ENG-CDR23021-R1-CDs-GEC-S1.pdf Markup Summary

Subject:
Page Index: 18
Date: 2/23/2024 9:10:43 AM
Author: Jeff Rice - EPC Engineering Review
Color: ■
Layer:
Space:
Page Label: [18] 18 POND GRADING PLAN

SHEET  
**GEC.1** 11

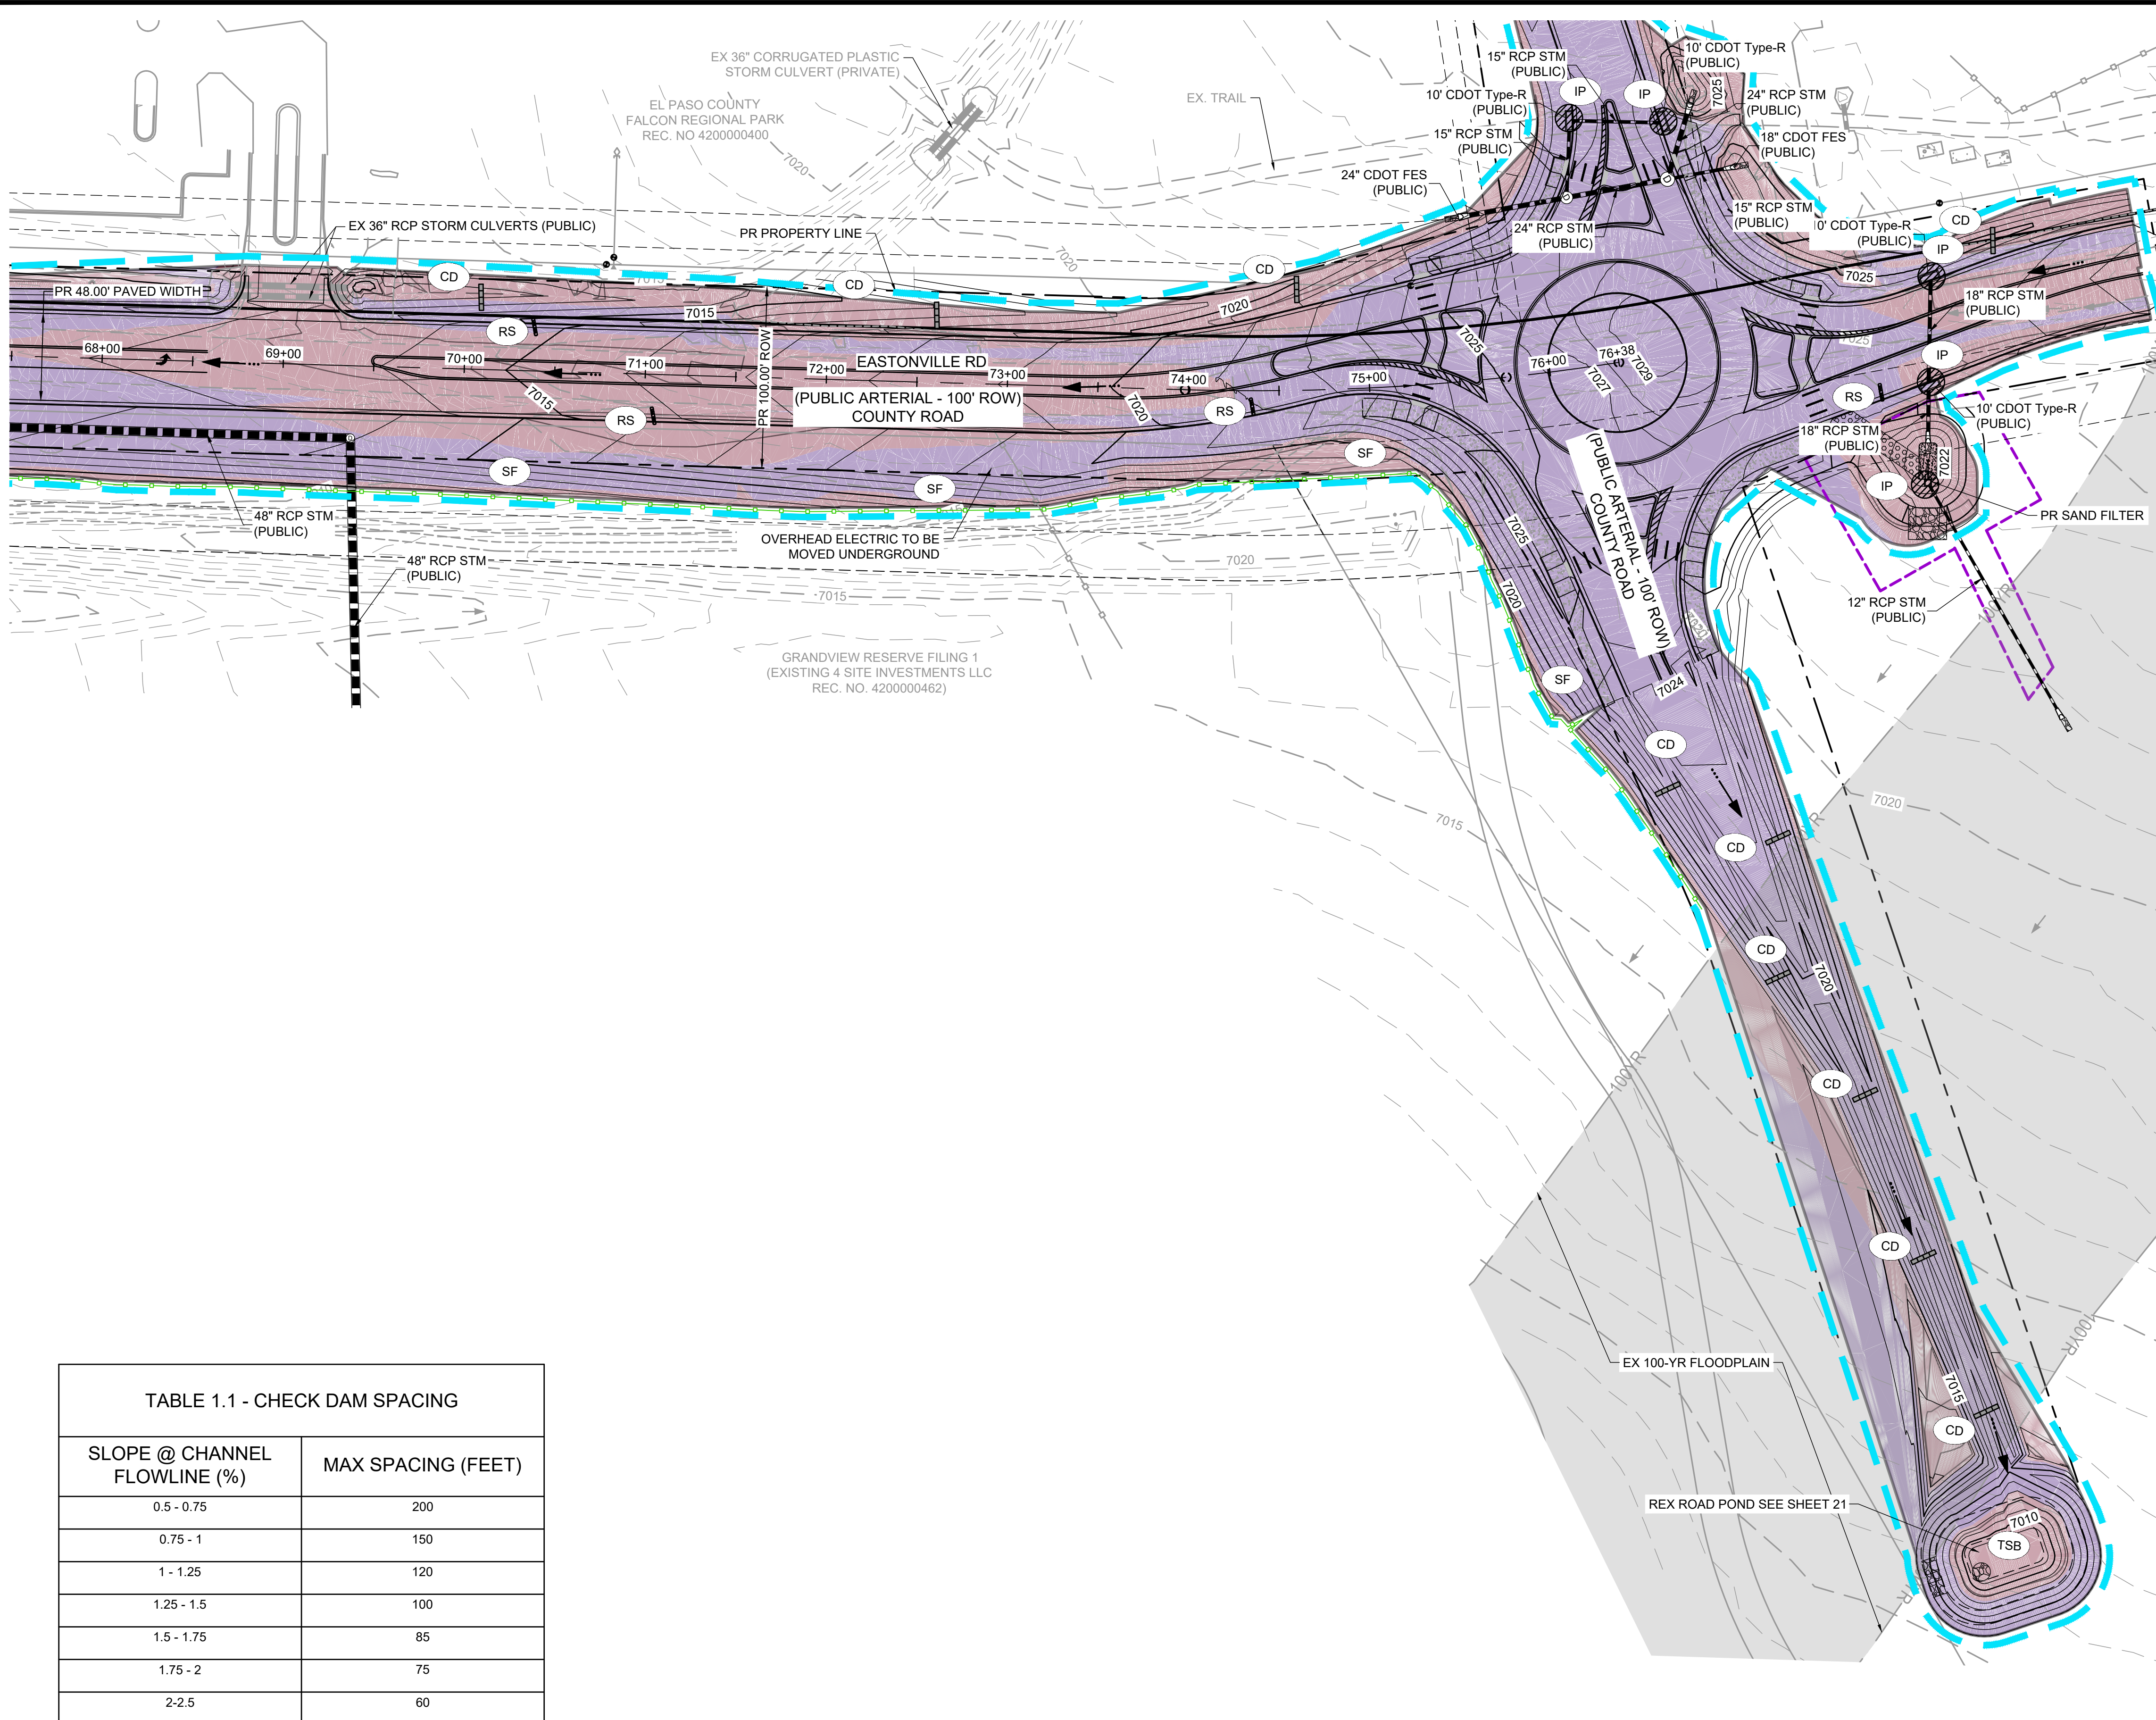
Is any stabilization needed here? Show drainage easement.

Show and label all easements needed

TSBs are required for disturbed areas >1ac.

Is this going to be used as a TSB? If so, label accordingly. And:

Provide details of temporary sediment basin including riser pipe diameter and perforation sizing, number of rows of holes, required volume, location of outlet pipe and spillway, and tributary area to the sediment basin. And provide contours for sediment basin.

Add these notes to the Segment 2 GEC Plan

No details provided on Sht 4 or any other sheet. Provide the 29 Notes listed on GEC Checklist pages 4-6.

Provide details for all temp BMPs shown on GEC Plans.

Is this floodplain line frozen?

GEC Checklist Item "s" - provide more drainage flow arrows. Only a couple are currently shown.

Check dams to be installed a minimum of every 1.5' of vertical fall. Notate spacing and/or include a table for multiple slopes, based on your selected detail.

Since you have already provided a table, add to it which check dam type you anticipate because that will effect the spacing.

Clarify that this is "Sand Filter A"

SHEET  
**GEC.2** 12

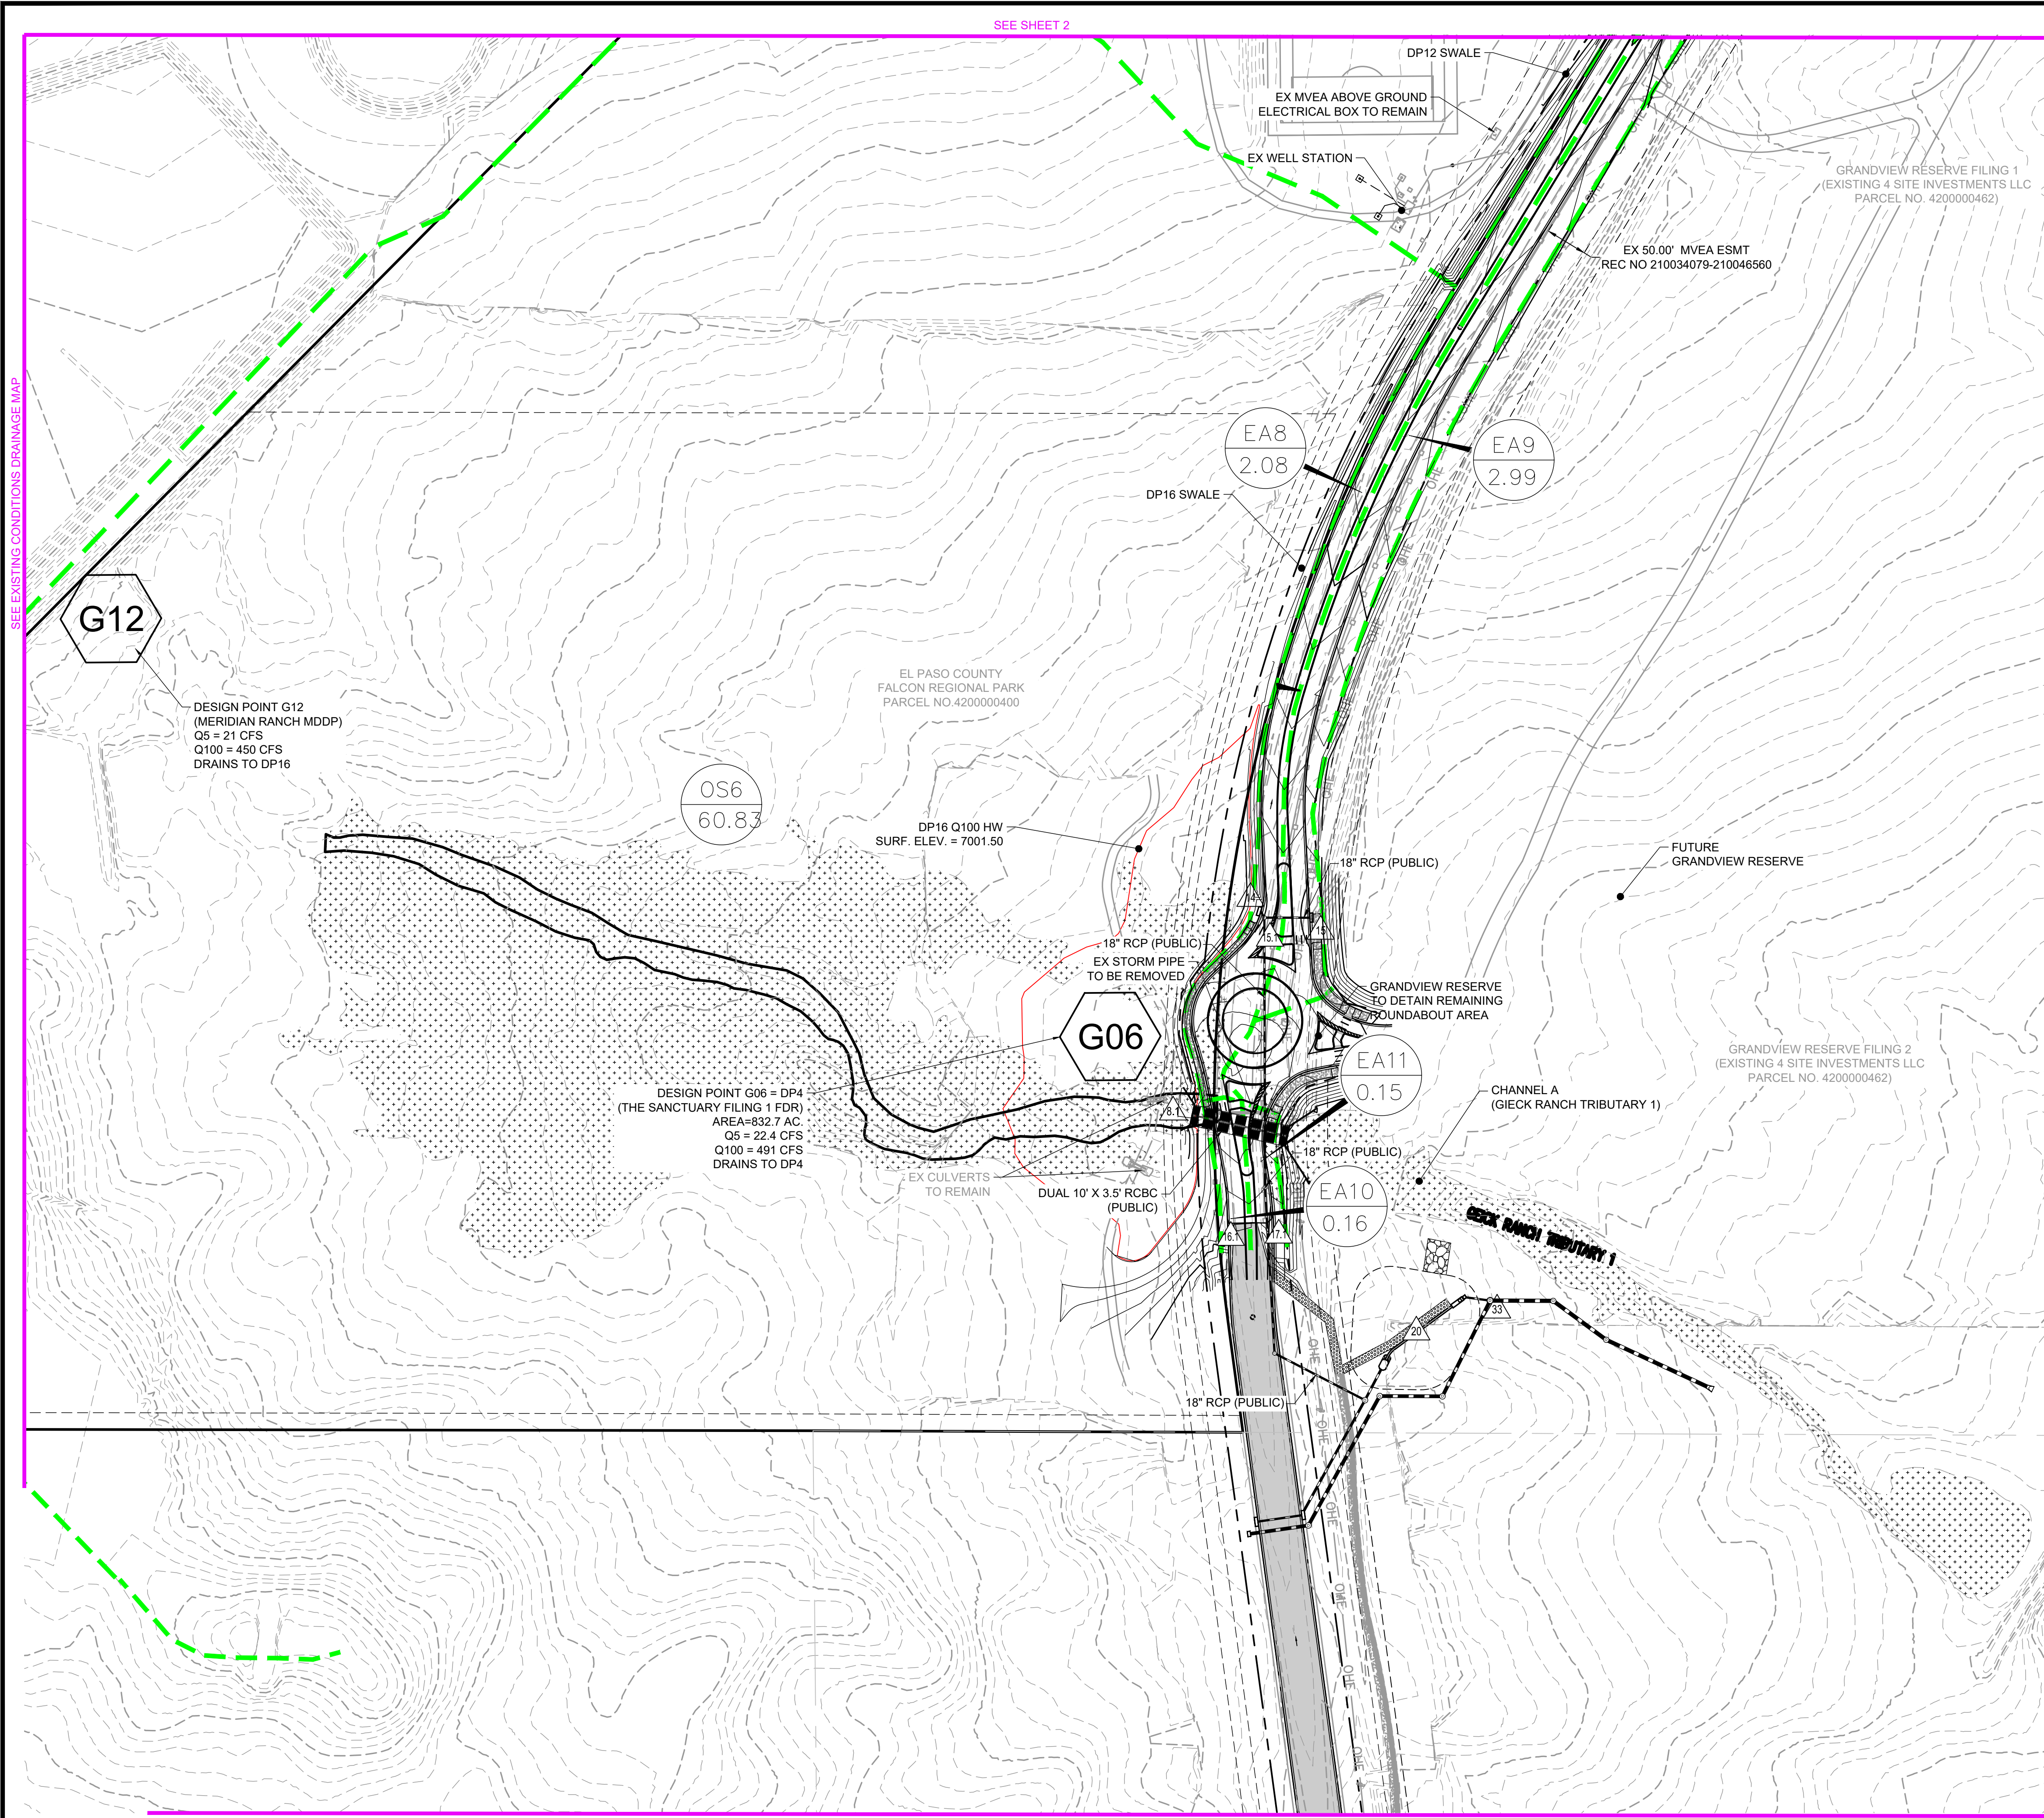
Indicate gas main depth and cover

This is labeled as "EDB B" on the FDR. Revise to remove discrepancy.

Per Jeff's comments on the road profiles, connect all proposed contours to existing grade.

TSBs are required for disturbed areas >1ac.

Is this going to be used as a TSB? If so, label accordingly. And:

Provide details of temporary sediment basin including riser pipe diameter and perforation sizing, number of rows of holes, required volume, location of outlet pipe and spillway, and tributary area to the sediment basin. And provide contours for sediment basin.

Consider need for VTC here
